EL PASO COUNTY

DEPARTMENT OF PARKS AND COMMUNITY SERVICES

April 4, 2024

Subject: Stonebridge Metropolitan District Nos. 1-6 Review (ID-24-001)

STONEBRIDGE METROPOLITAN DISTRICT NO. 6 INFRASTRUCTURE MAP

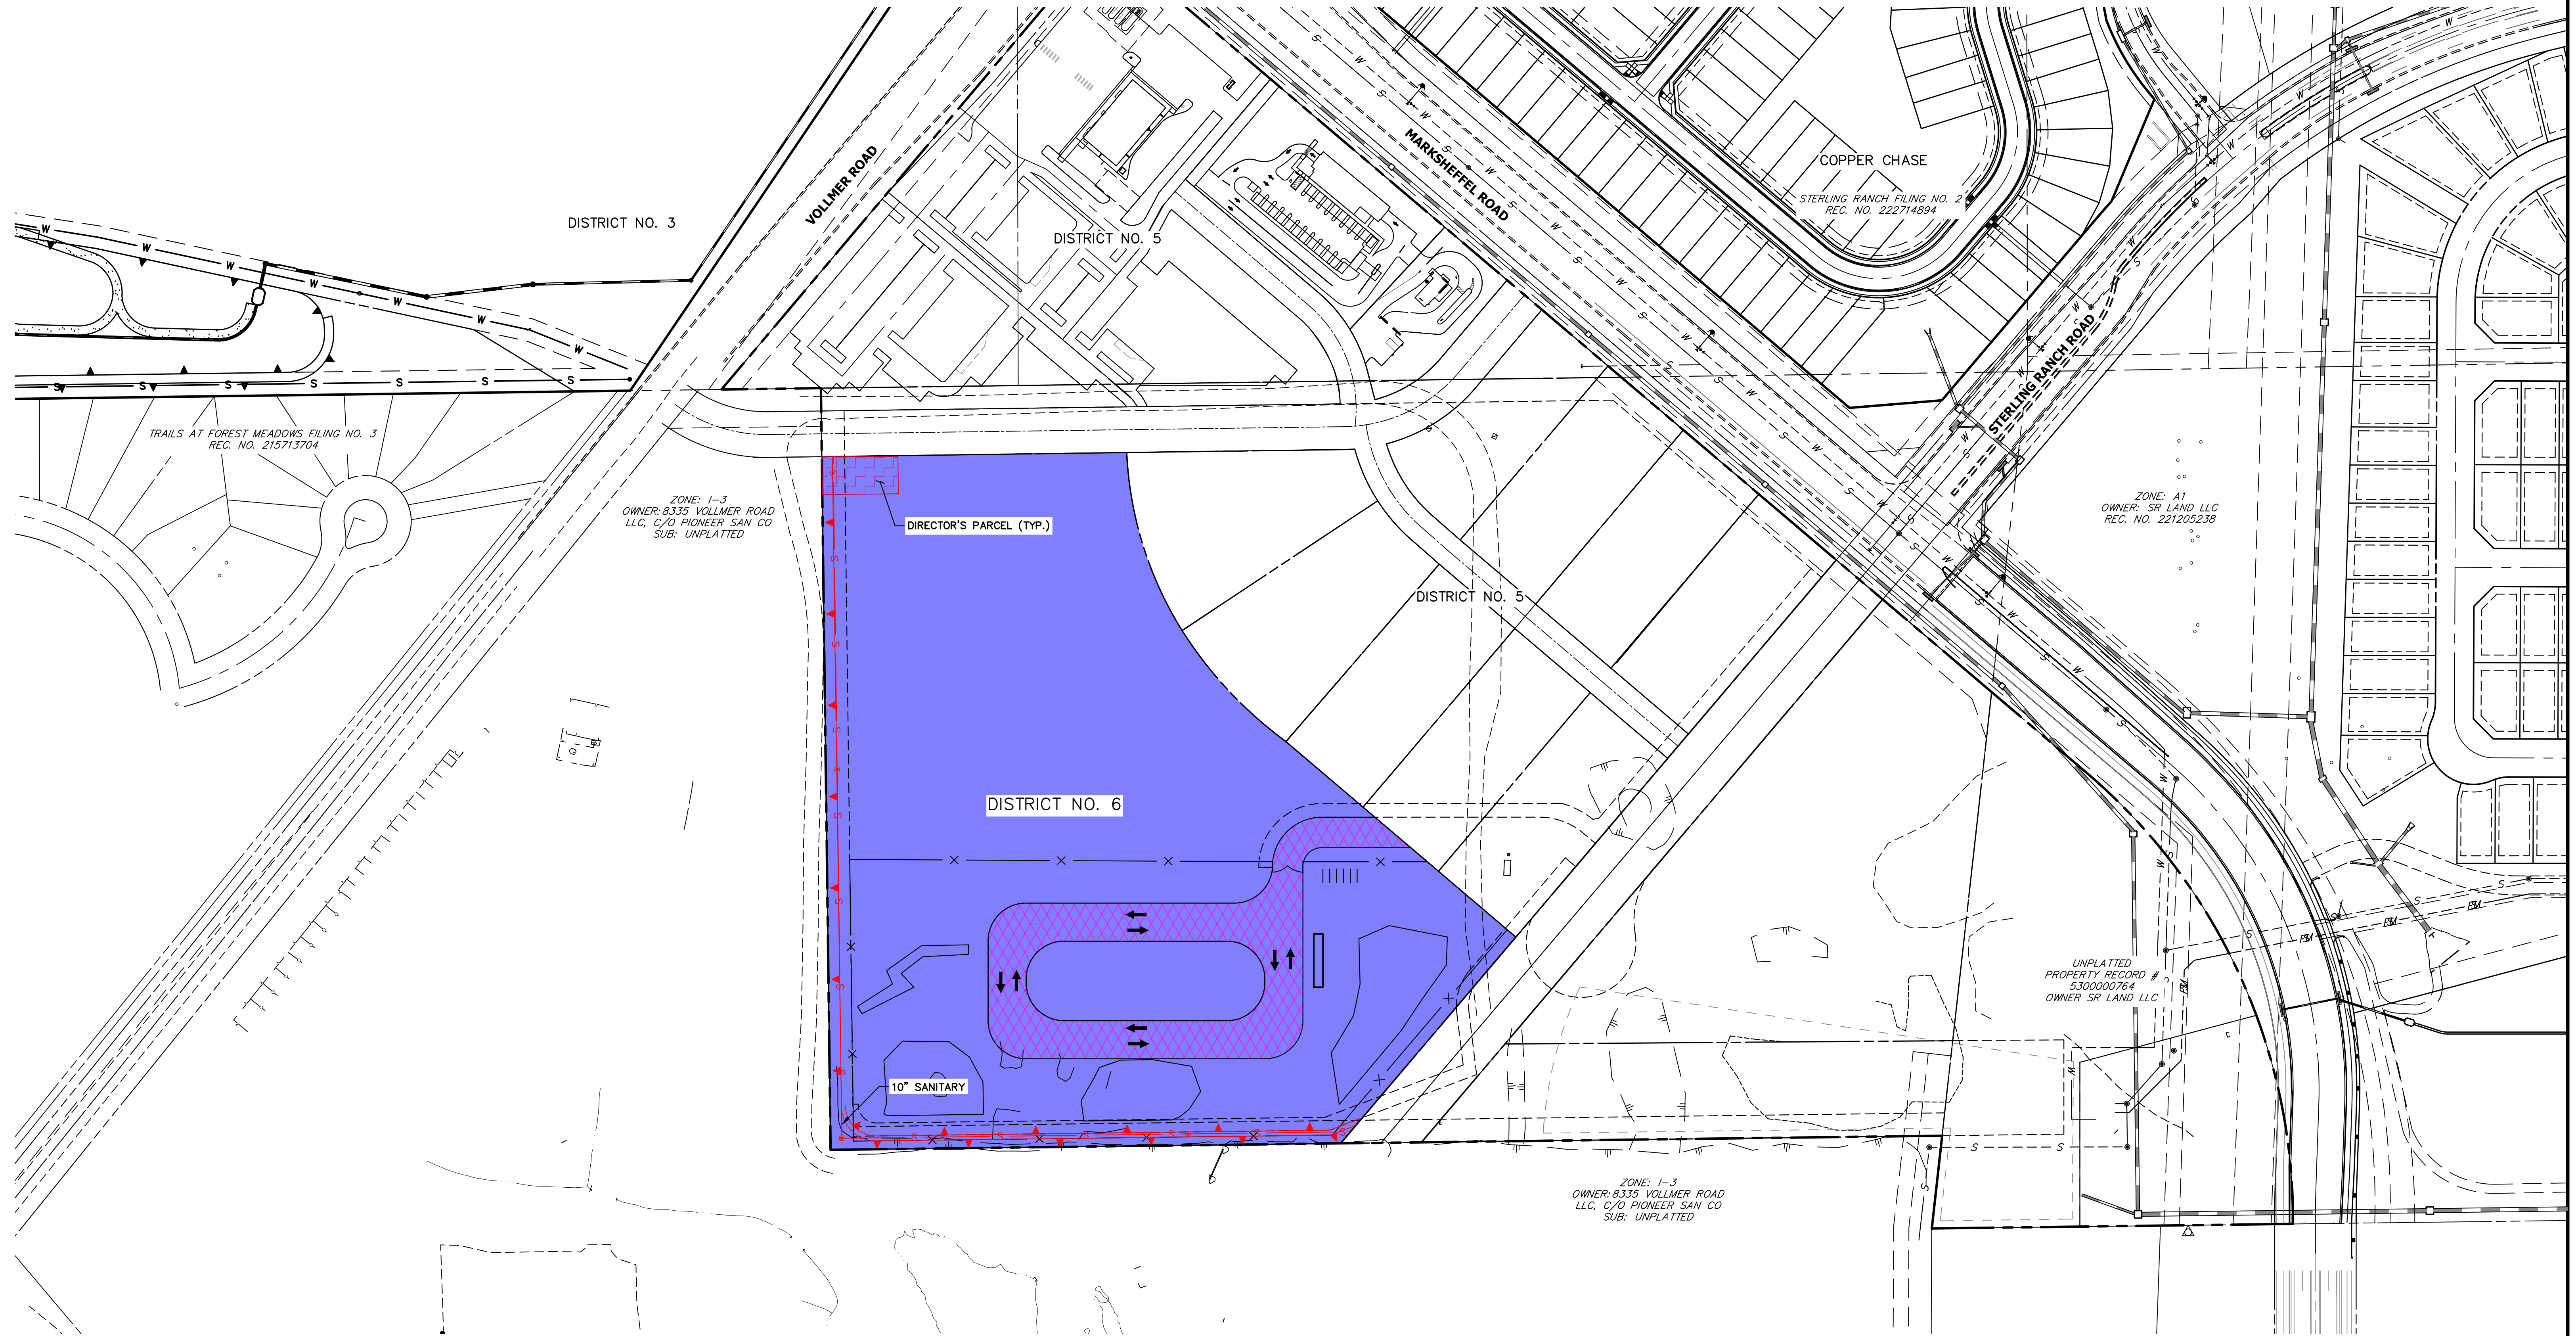
The applicant's Letter of Intent and proposed Service Plan make mention of future parks, trails, and open space, but these recreational facilities are not shown on the submitted Service Area maps. The Stonebridge Metropolitan District Service Plan and Letter of Intent do include the following statements in regard to parks, trails, and open space:

In conclusion, Parks staff is encouraged by the applicant's desire to bring high-quality recreational amenities to the residents and visitors of the Stonebridge community. However, staff recommends that the applicant include generalized plans, descriptions, and locations of these recreational facilities in either the Letter of Intent or included in the Service Area maps, as with other planned improvements, such as roadways, sewer and water deliver systems, and stormwater detention facilities.
